Engineers Comments Regarding Surface Water Drainage

Application Reference:	Y/24/26/PL	Reviewer Reference:	ADC/ETX4b
Planning Officer:	Amber Willard	Date of Review:	18/08/2026
Site Name:	Sunnymead North End Road Yapton BN18 0DL		
Application Description:	Retention of fence at west of site on North End Road, hardstanding and access track and the creation of a residential caravan site with 3 No plots with associated parking, landscaping and facilities (resubmission following Y/57/24/PL). This application is a Departure from the Development Plan and is in CIL Zone 3 (Zero Rated) as other development.		
Assessment Number:	2

Reviewed Plans

flood storage compensation lowering to 2.4 from 3.0
CUT
54m² @ 0.7m 37.8 m³
11m² @ 0.65m 7.1 m³
12m² @ 0.55m 6.6 m³
13m² @ 0.45m 5.8 m³
14m² @ 0.35m 4.9 m³
15m² @ 0.25m 3.7 m³
16m² @ 0.15m 2.4 m³
17m² @ 0.05m 0.8 m³
69.1 m³

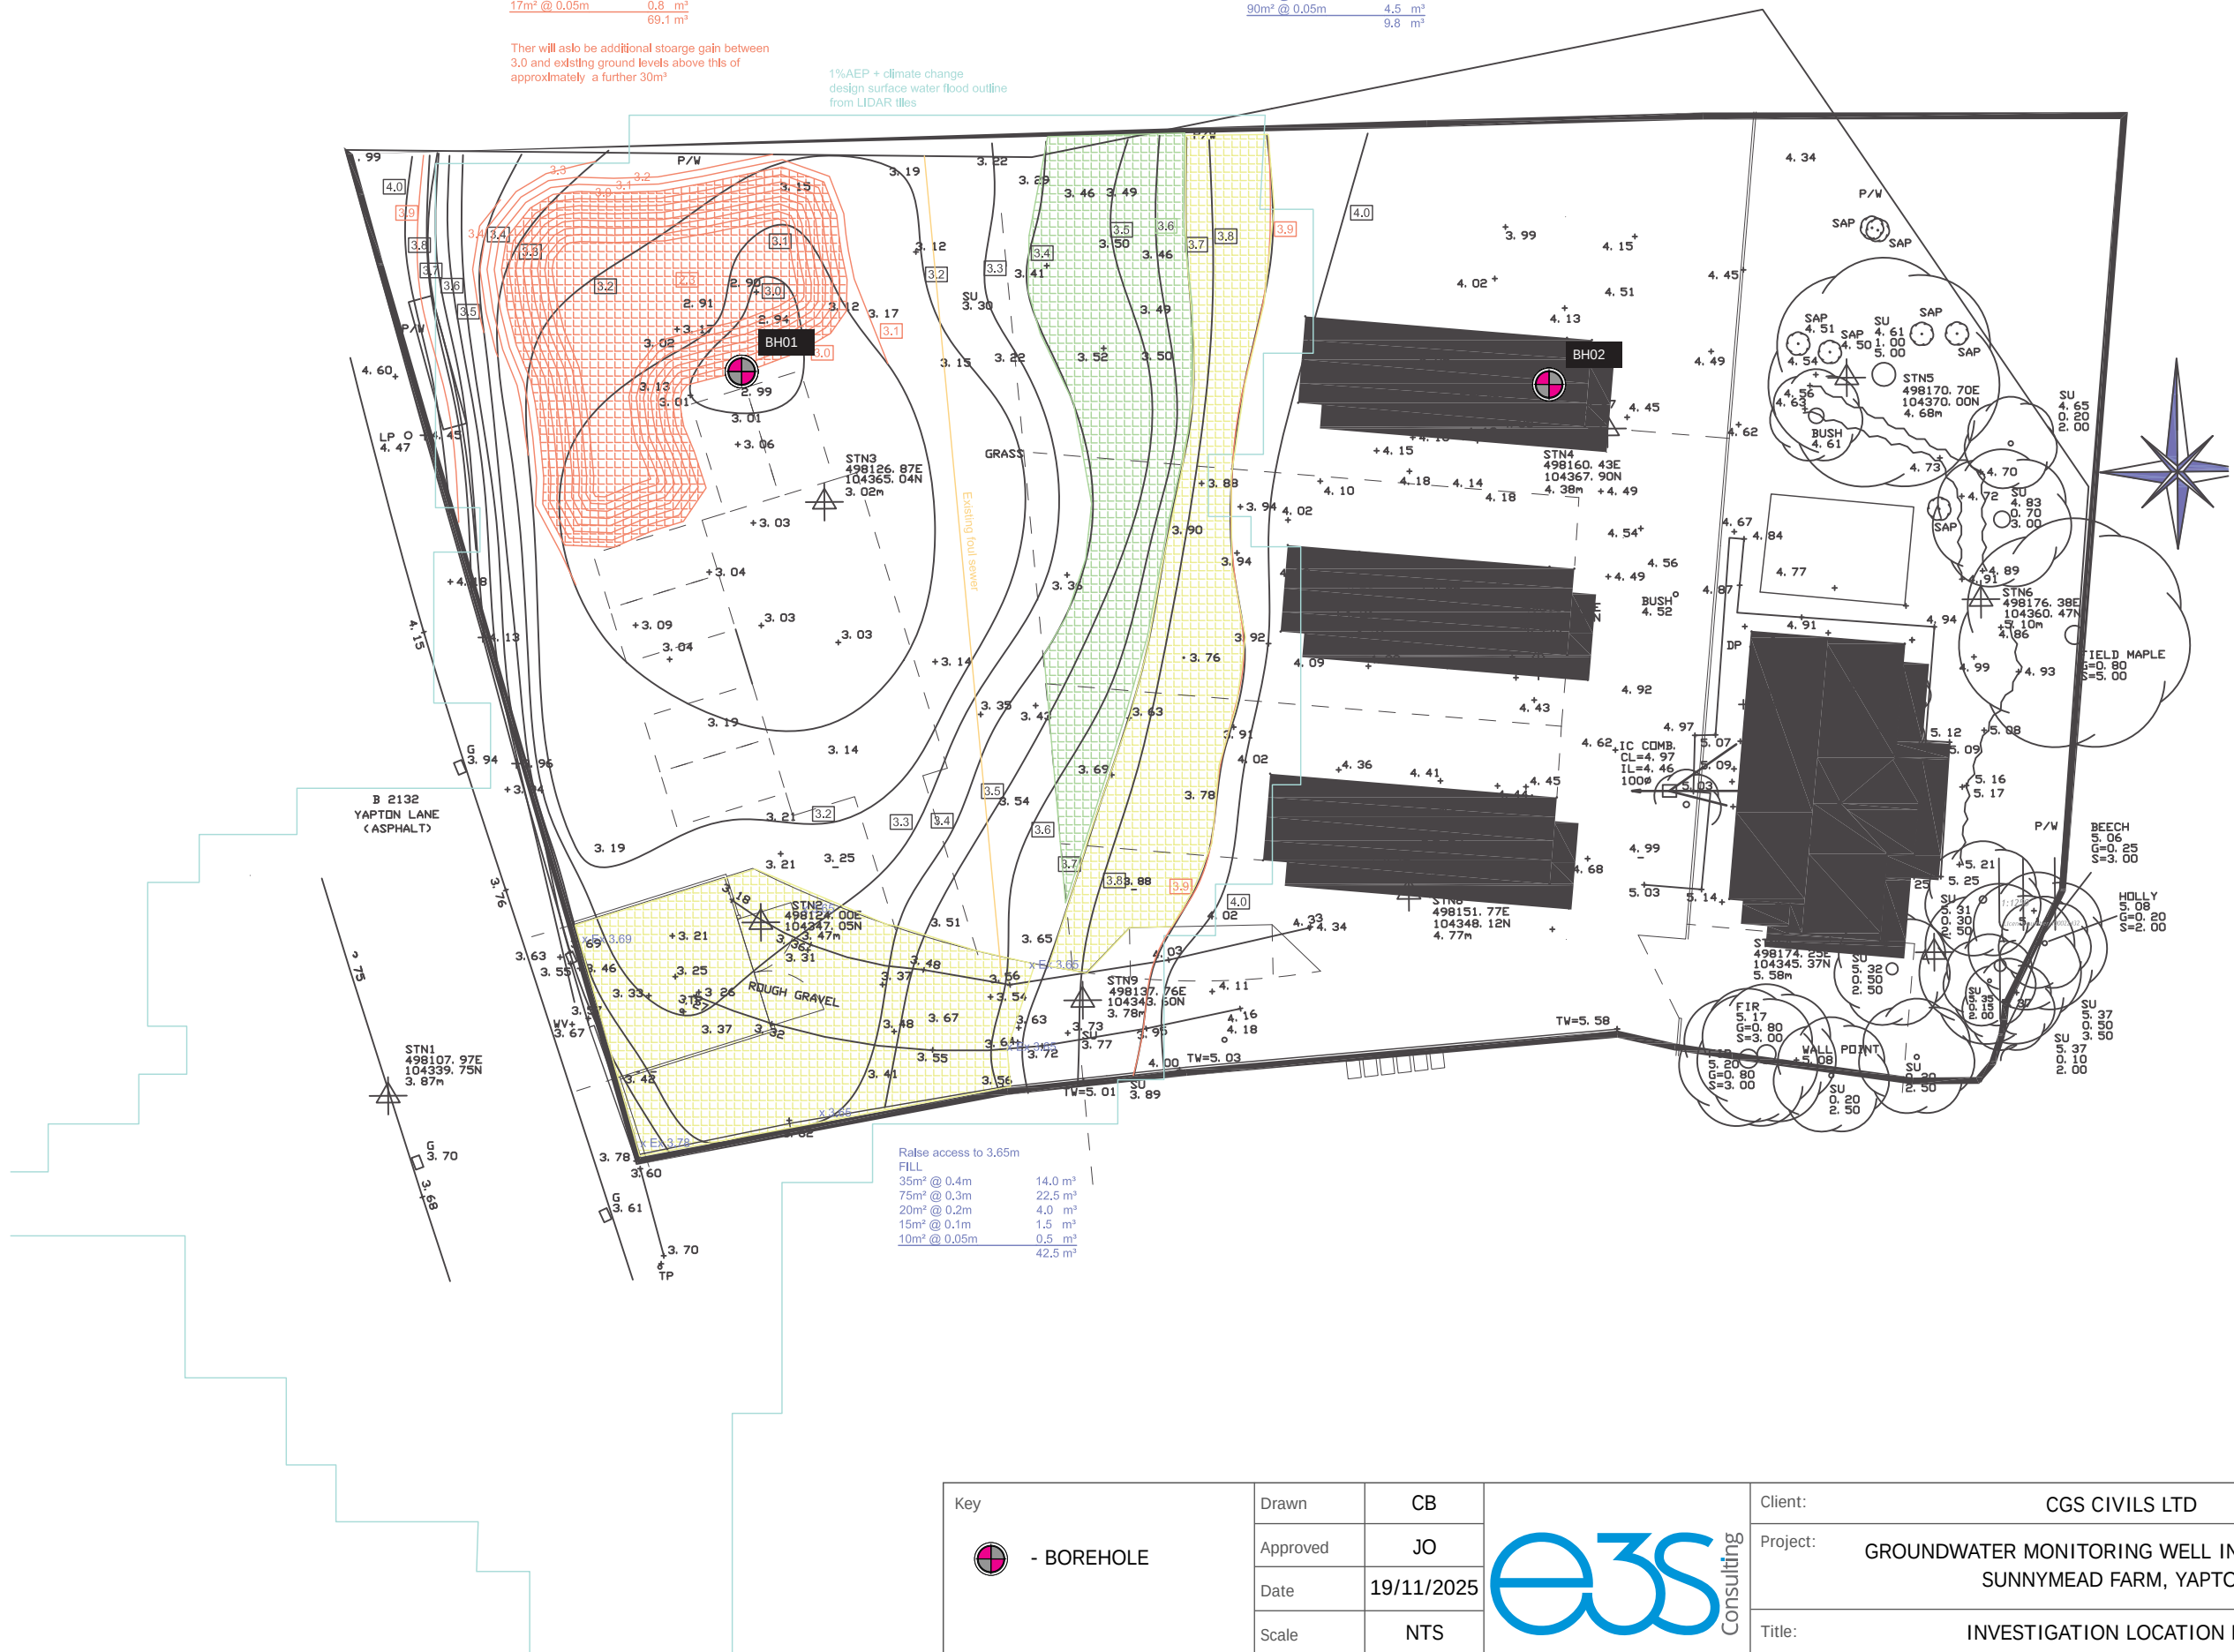
3.5. At present, the submission does not demonstrate compliance with volumetric compensation adequately. The description and tables (on drawings EX FL-01 and FL-01) justifying the approach used are not clear enough. If a new application is made, then it will be expected that the tables and workings are clearly explained. At present there is no explanation for these tables, and the volumes do not appear to align with the plan areas quoted.
